Change of use from shop (A1 Shops) to micro-pub (A4 Drinking Establishment).
42 Barnham Road Eastergate

Thank you for your internet representation made on 10th August 2018 which has been recorded as '**an objection**' with the comments as follows:

PROPOSED GROUND FLOOR PLAN 1:100

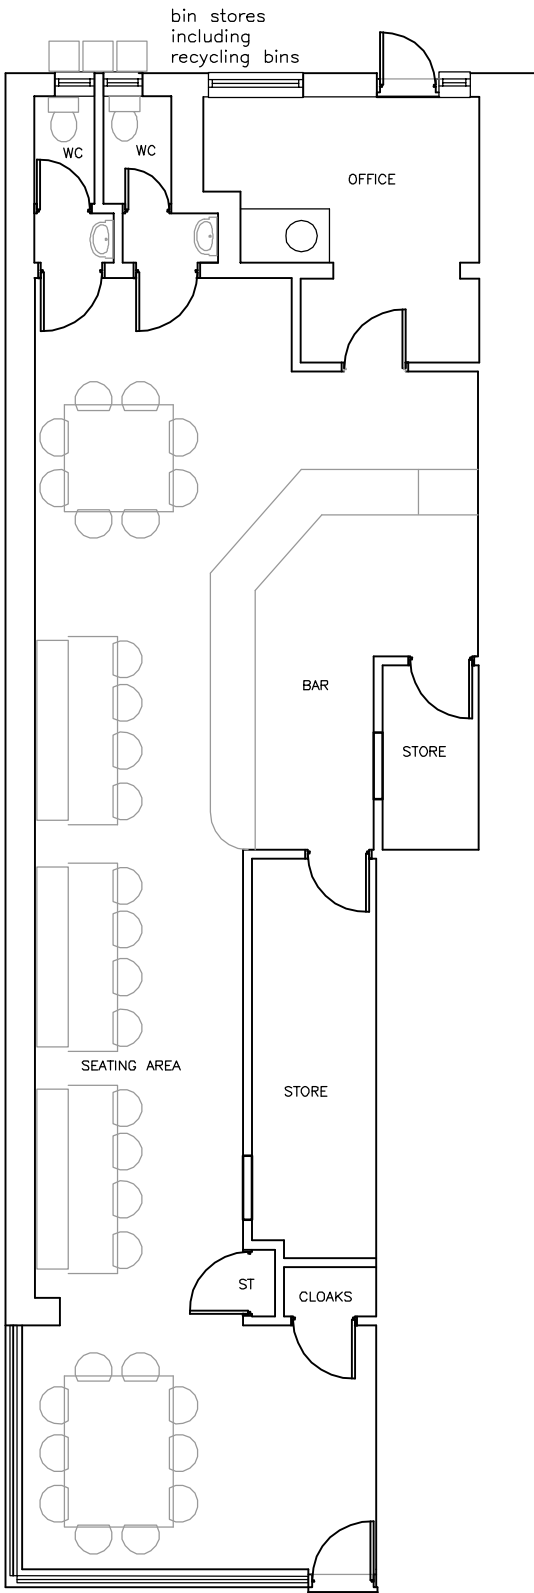
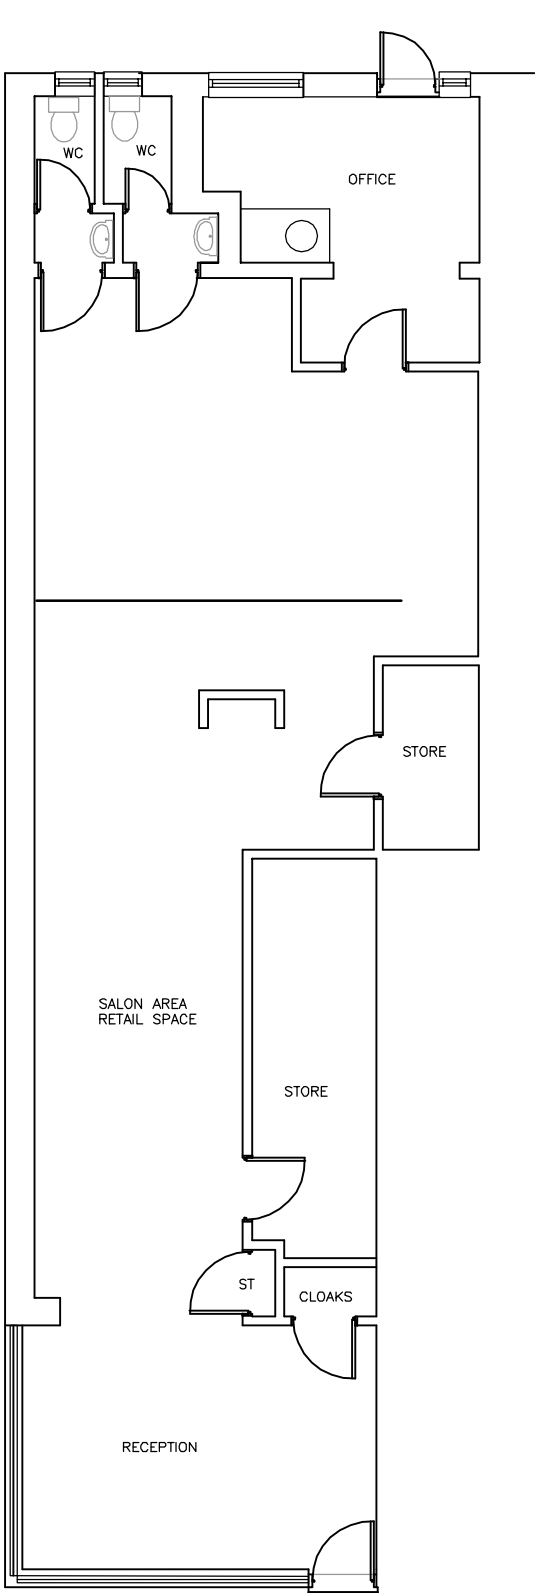
124.00 sq.meters with 40 - 60 people shoehorned into an area of that size has the potential to create high levels of fluctuating and resonating background noise, therefore, having a detrimental impact on the existing residents dwelling in the two flats above.

The proposed seating area for 8 people will cause a hazardous obstruction and a potential risk by protruding on to the pavement and will therefore significantly narrow the public pathway/walkway and almost blocking access to the dropped kerbs which are situated on the corner on both sides of the road at the entrance of Saxby close. The dropped kerbs are there to serve an important purpose and are extremely crucial to people with mobility/disability issues such as the blind, parents with children and pushchairs, mobility scooters and the elderly.

A clear route/walkway should be maintained at all times for passing pedestrians without causing hindrance or obstruction, The layout of the seating area should not protrude on to the public walkway so much so that it narrows or develops a hazardous obstruction/restriction, therefore, forcing the passing pedestrians dangerously close to an already busy fast moving road.
